**Project:** Cadenza – MetroLink Submission

**Job No:** 18-020

**Subject:** Review of MetroLink Rail Order

**Date:** 20 March 2024

TUNNEL ALIGNMENT
SAINT STEPHEN'S GREEN – CHARLEMONT
RO APPLICATION VS DEEPER VERTICAL ALIGNMENT OPTION

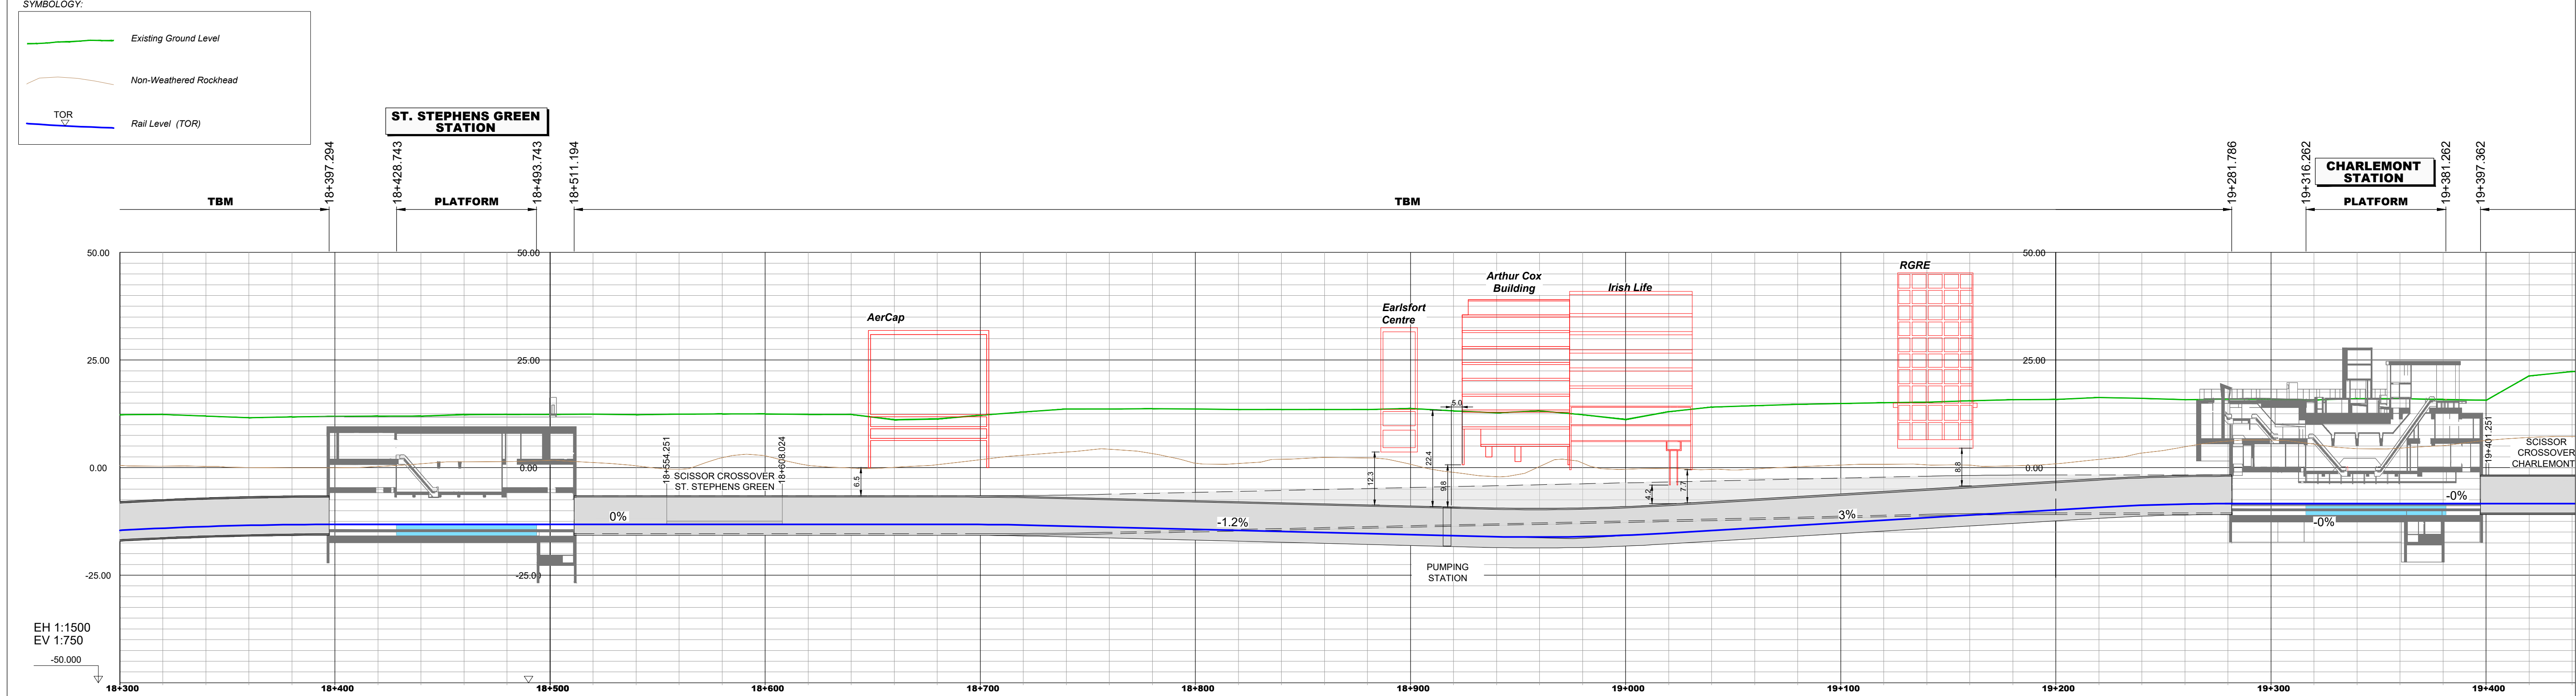
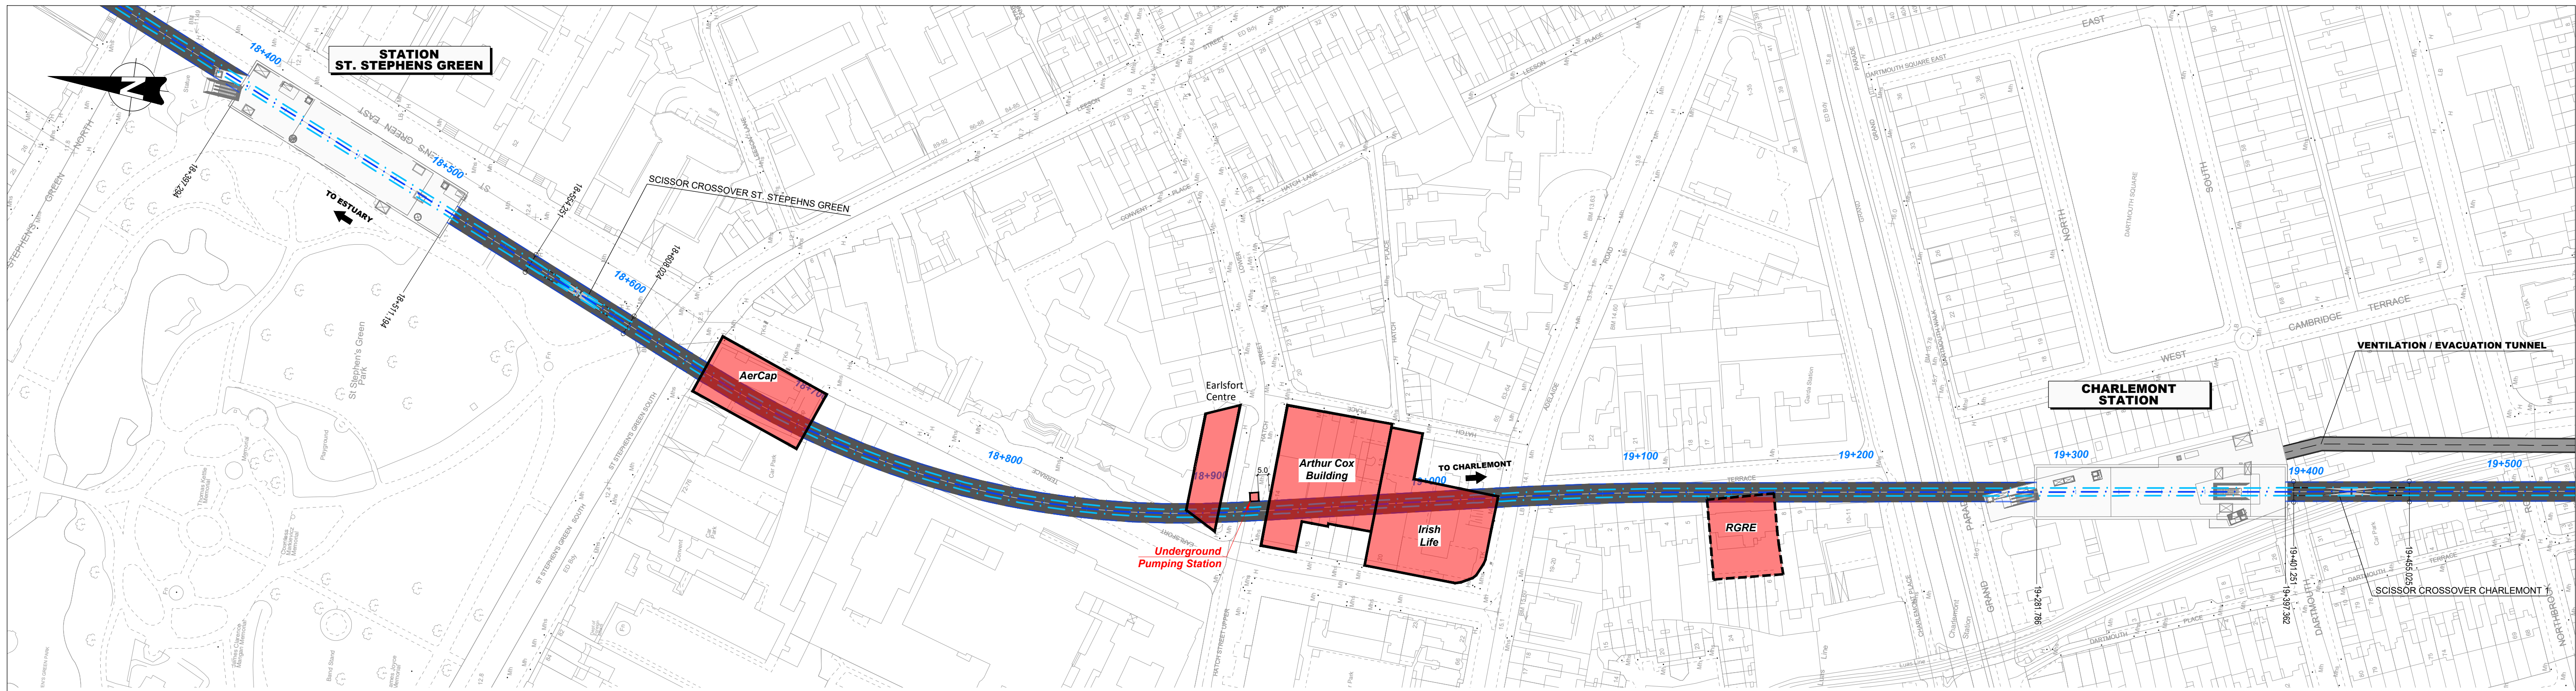
The "EIAR Addendum Downward Realignment St Stephens Green Station to Charlemont Station", which incorporates the lowering of the Metrolink Tunnel to avoid clashing with the existing tension anchors, has reassessed the expected settlement/subsidence due to the Metrolink Tunnel.

The expected settlement/subsidence has now further reduced to 19.45mm and has been categorised as negligible. We believe that this categorisation is incorrect.

As previously stated in our initial submission, the level of damage the Cadenza Building could reasonably accommodate is less than 0.1mm. Even at this level, there are still concerns that the basement waterproofing system will be compromised and that remedial work will be required to be done to an occupied building.

If the Metrolink Tunnel is to pass under or close to the Cadenza Building, we require a detailed Phase 3 assessment using the correct building geometry and structural form to be completed and independently verified, ensuring the maximum damage caused to the Cadenza Building is limited to 0.1mm cracking. We still believe the proposed tunnel elevation may need to be lowered further, possibly more than the current LOD downwards would allow.

Figure 10: Imposed vertical Loadings - Bored Tunnel

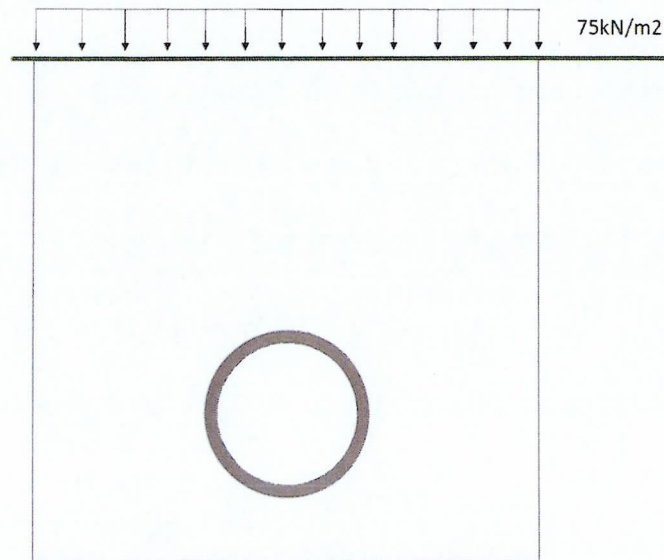
In addition, section 2.1.4 of the Draft Guidance Note For Developers document and figure 10 confirm:-

- The tunnel lining design has been prepared on the basis that the bored tunnels are able to carry an over-site load of  $75\text{kN/m}^2$ . The imposed vertical loading for the tunnels is shown diagrammatically in the following.

If this level of load limiting is imposed due to the Metrolink Tunnel, it would not be possible to build a traditional house, let alone extend or rebuild the Cadenza Building, which imposes  $1000\text{kN/m}^2$  at the underside of the foundation level directly above the tunnel.

The conditions imposed by the Metrolink Tunnel would preclude either the vertical extension or future redevelopment of the Cadenza Building, and the exclusion zone would also appear to preclude the deepening of the existing basement level.

We are concerned that TII has not adequately considered the level of foundation loading so close to the Metrolink Tunnel.

TII should be required to design and construct the tunnel to ensure that the tunnel's loading tolerances beneath the Property will be capable of supporting the construction of an additional two storeys on top of the Cadenza Building.
